Our ref: NO/2021/113355/04-L01
Your ref: 3/2021/0205
Date: 22 October 2021

**ERECTION OF 36 RESIDENTIAL DWELLINGS, ALONG WITH LANDSCAPING AND ASSOCIATED SITE INFRASTRUCTURE.
LAND AT NEDDY LANE, BILLINGTON, BB7 9LL**

We have reviewed the revised FRA for the development produced by Banners Gate, reference 20023_FRA, Rev 03, dated 04/10/21 and wish to maintain our objection to the proposed development.

Proposed Flood Plain Compensation Scale 1:250

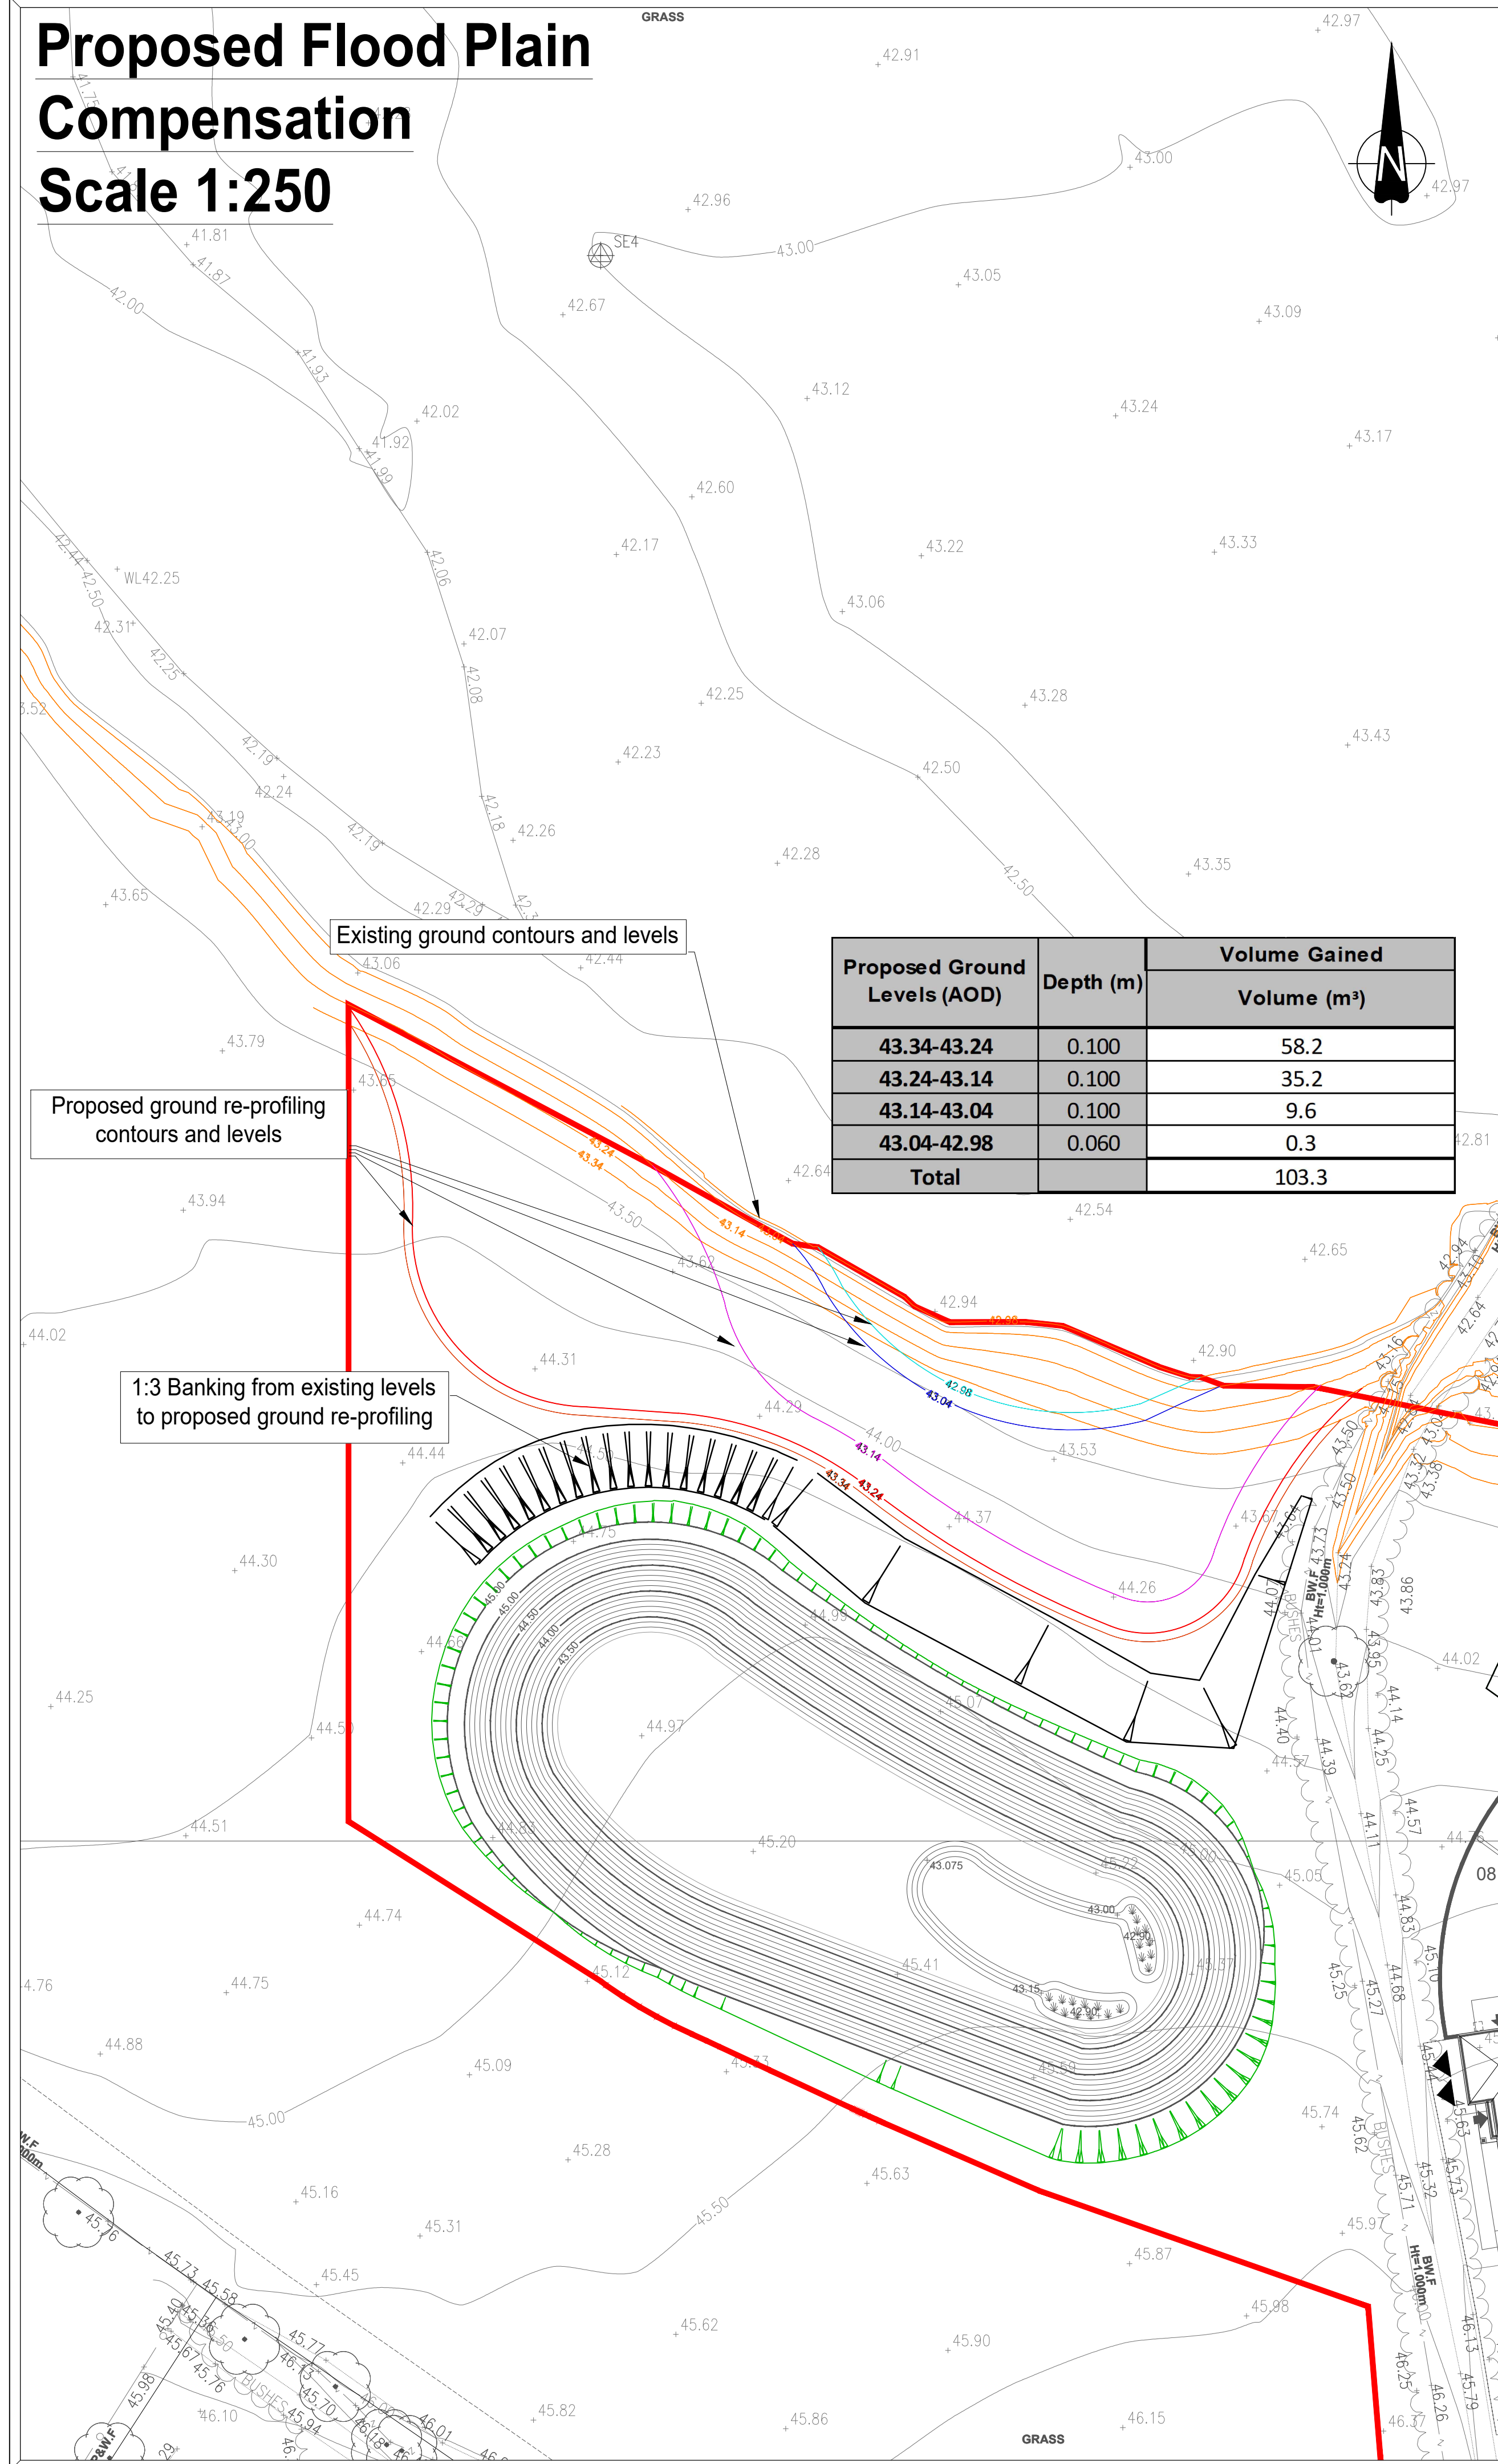
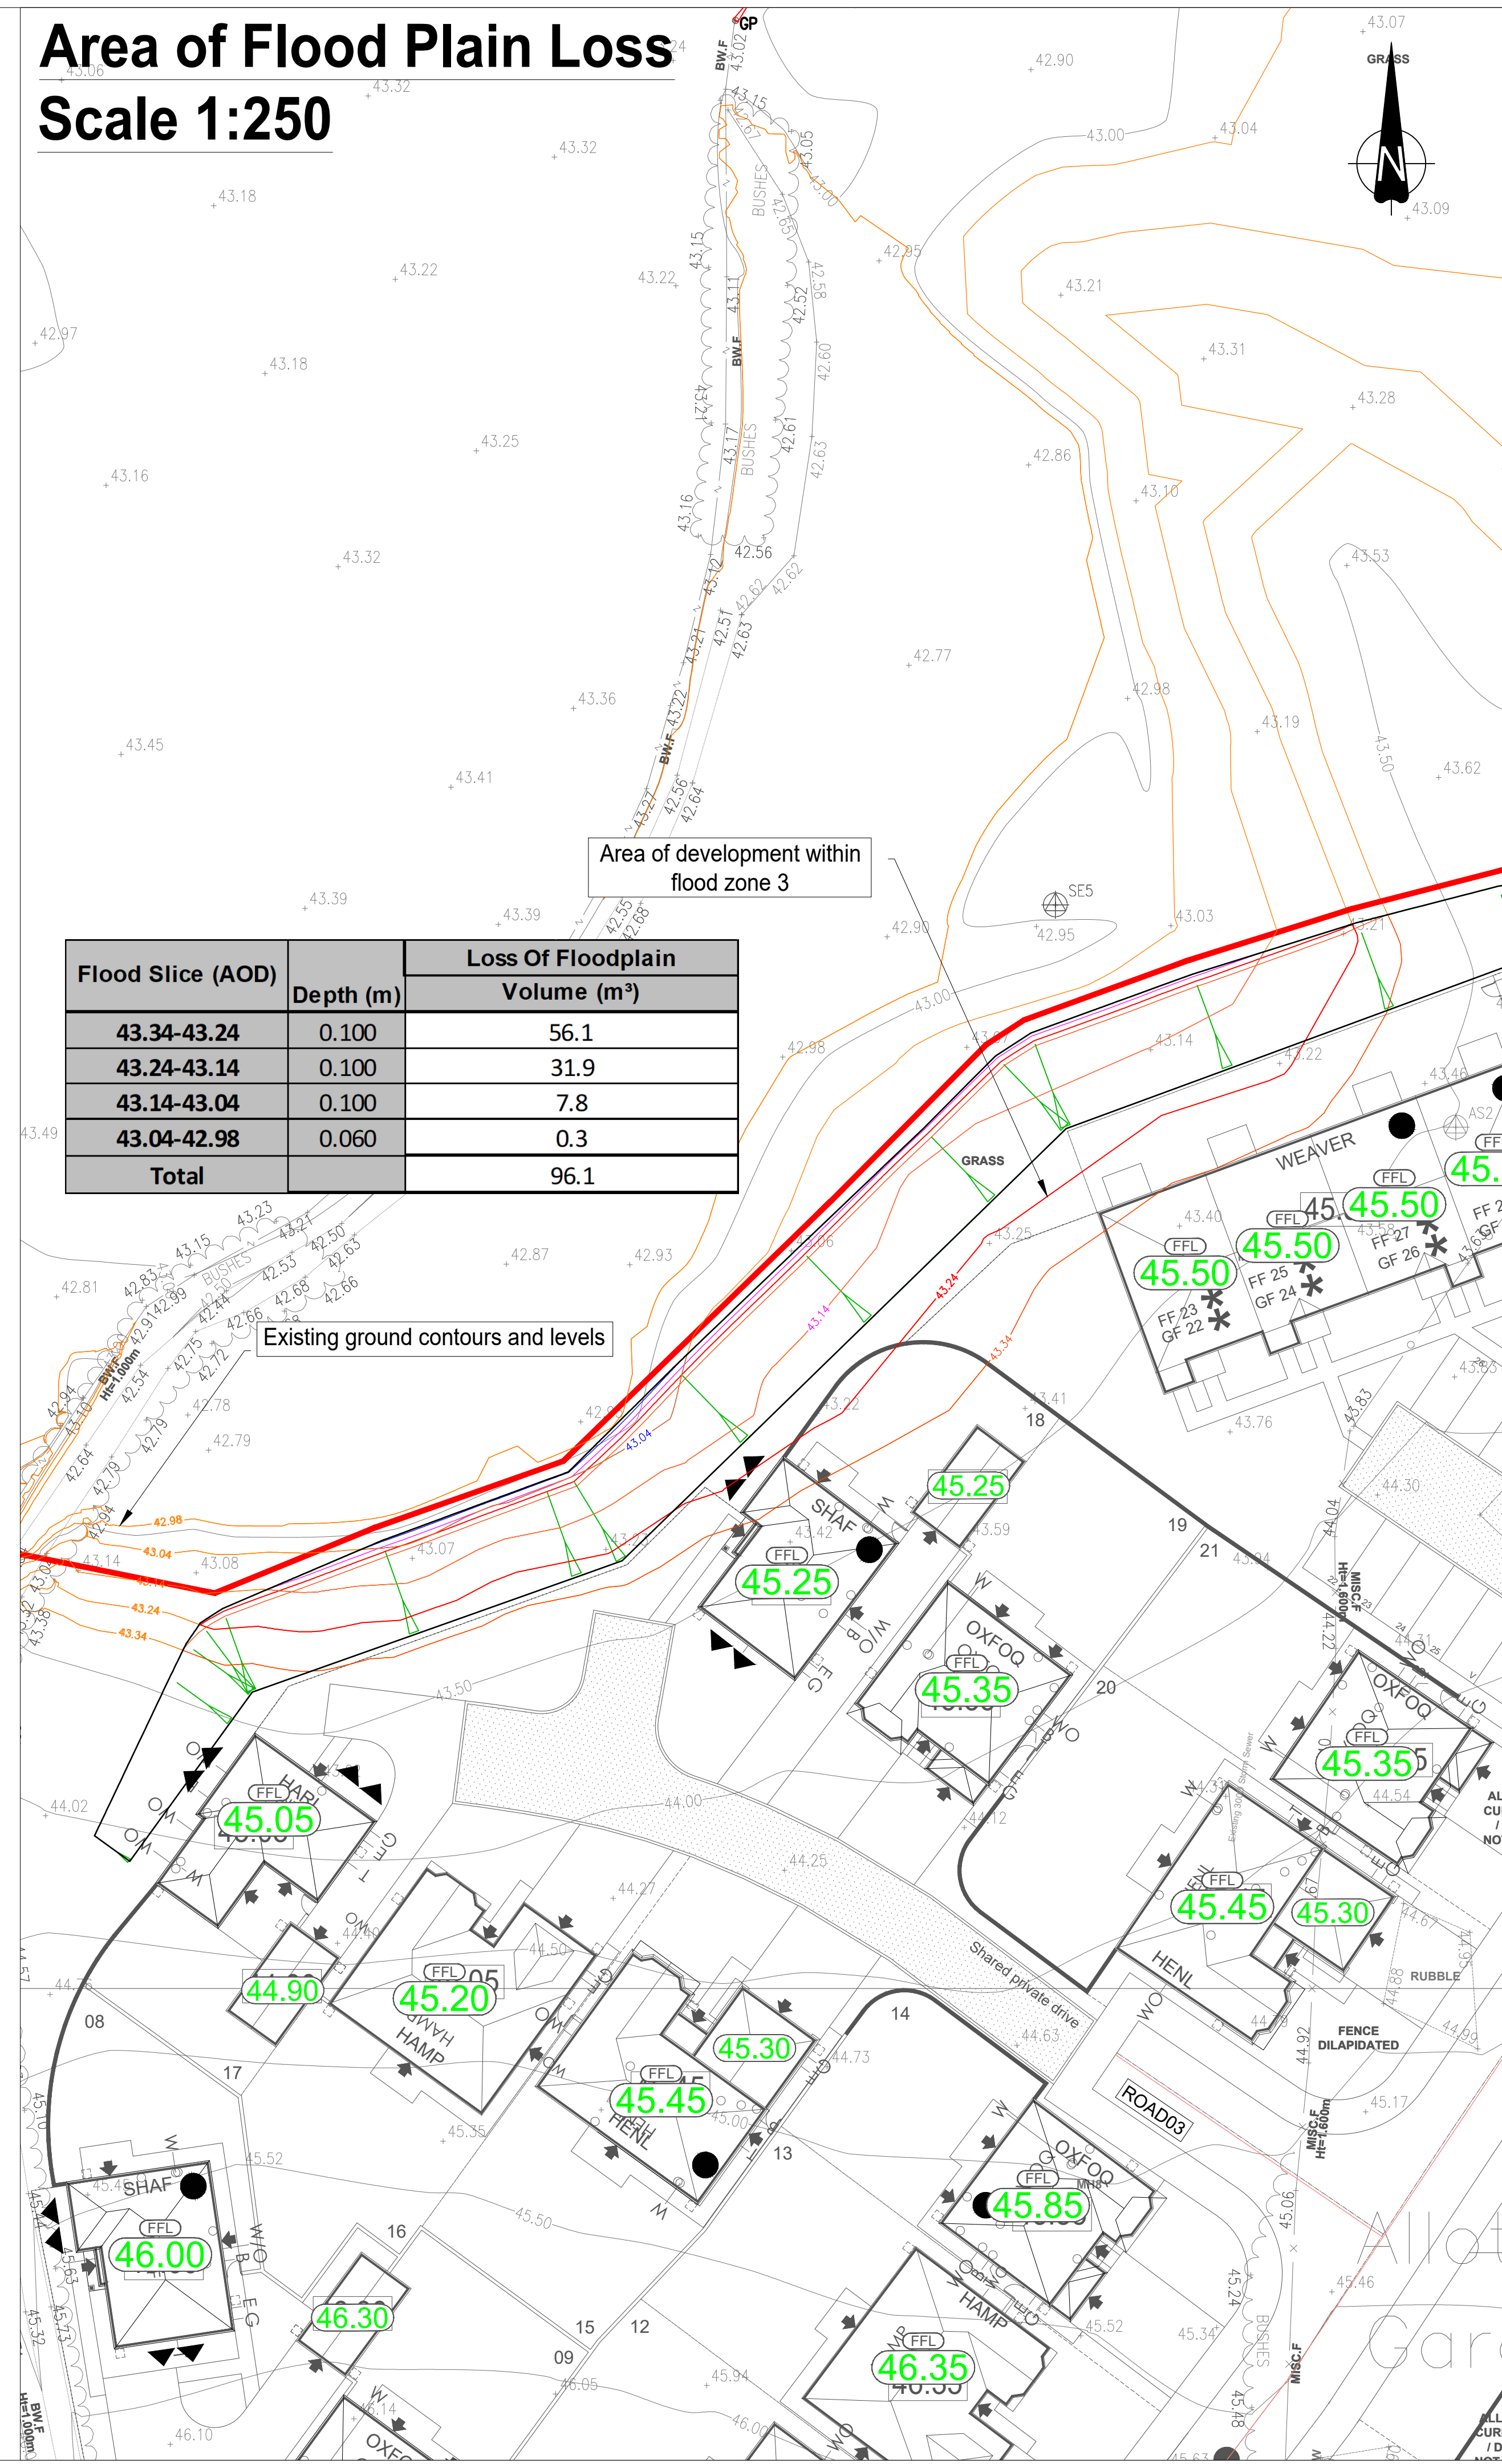
The application does not provide adequate justification for why the applicant is not proposing a direct compensatory storage scheme i.e. providing level-for-level storage by providing scrapes/ re-contouring of land adjacent to the existing flood plain (flood zone 2 in this instance as the 0.1% AEP event is being used as a proxy for the climate change allowance).

We also wish to clarify that our earlier flood risk comments which indicated that the scheme provided "betterment" only relate to the volumes detailed in the tables on the flood compensation drawings, not the overall scheme.

The applicant should propose a direct compensatory storage scheme that provides adequate flood compensatory storage at the correct volumes and levels adjacent to the current flood extent
